PLANNING CONSULTATION RESPONSE

Application No	2026/0021
Proposal	Proposed two storey side and rear extension, and rear extension at a lower level to accommodate a gym and swimming pool.
Address	53 Keresforth Hall Road, Kingstone, Barnsley, S70 6NL.
Date of Consultation Reply	24/02/2026
Consultee	Edward Jowett (Tree Officer)

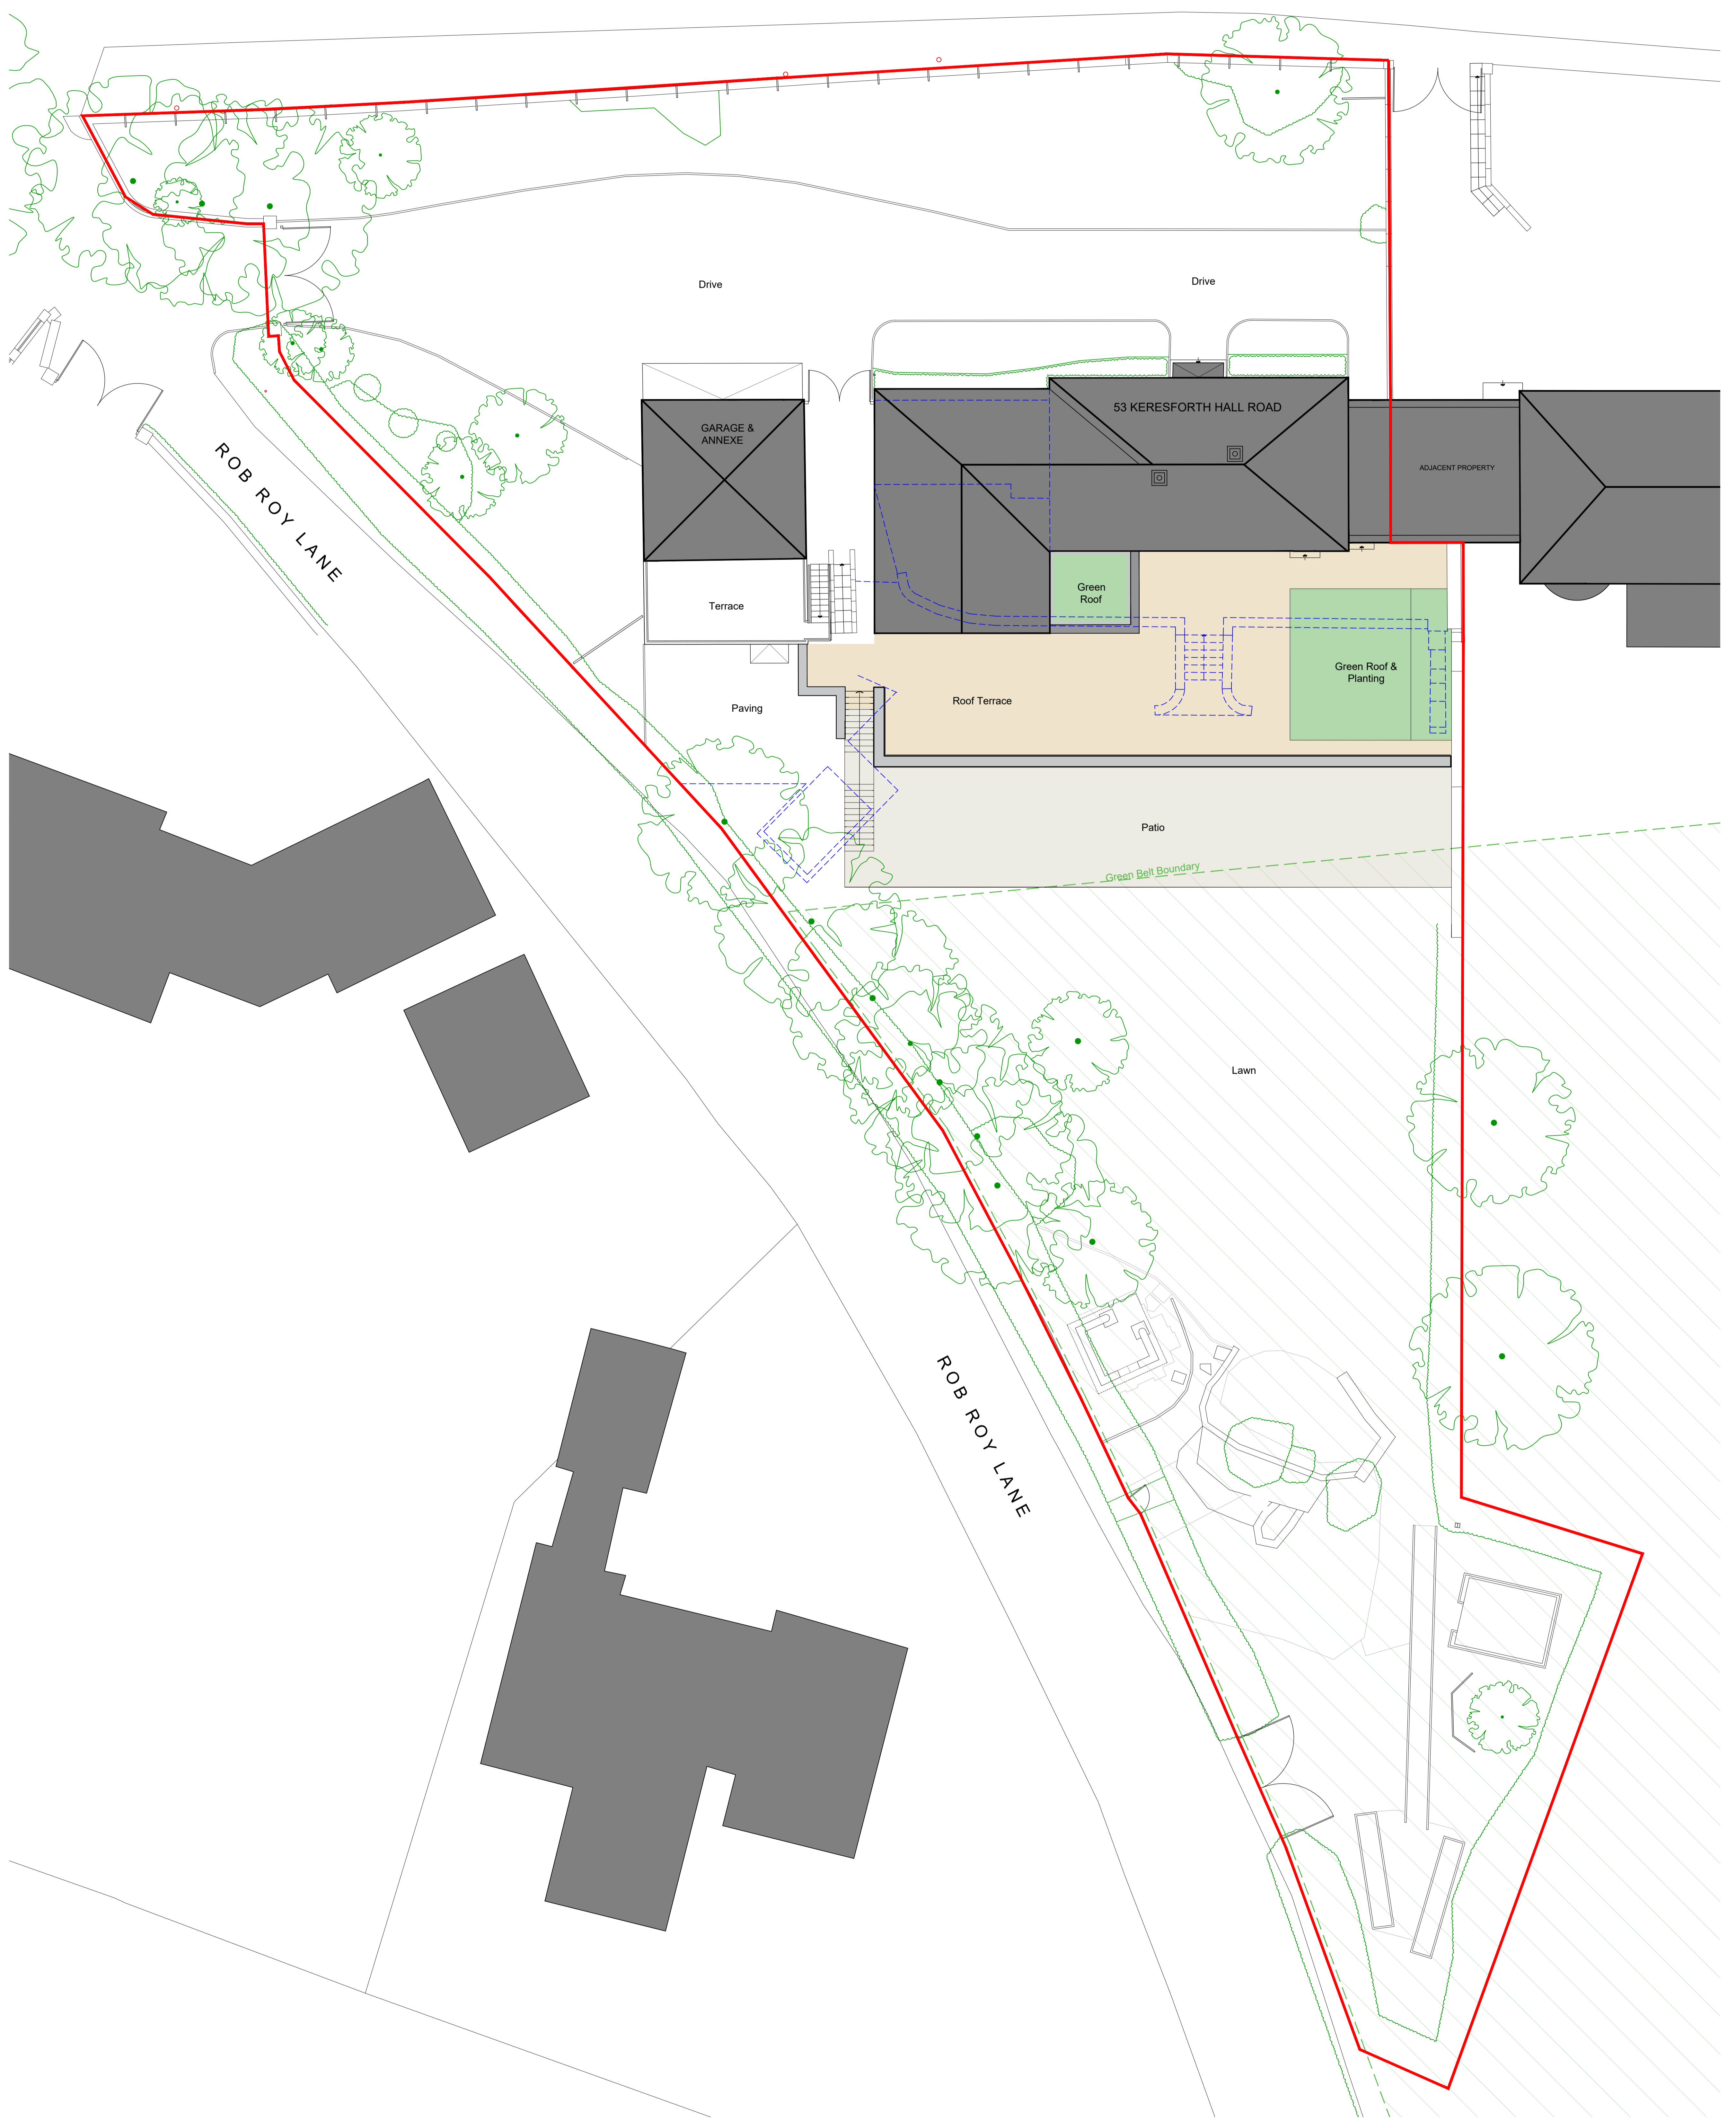
The works proposed as part of this application will take place in close proximity to trees; yet no arboricultural information has been provided as part of the application. The impacts on these trees are therefore unquantified and as such I would ask that a tree survey and arboricultural impact assessment to BS5837:2012 be provided to identify the trees and the implications of the proposed development works.
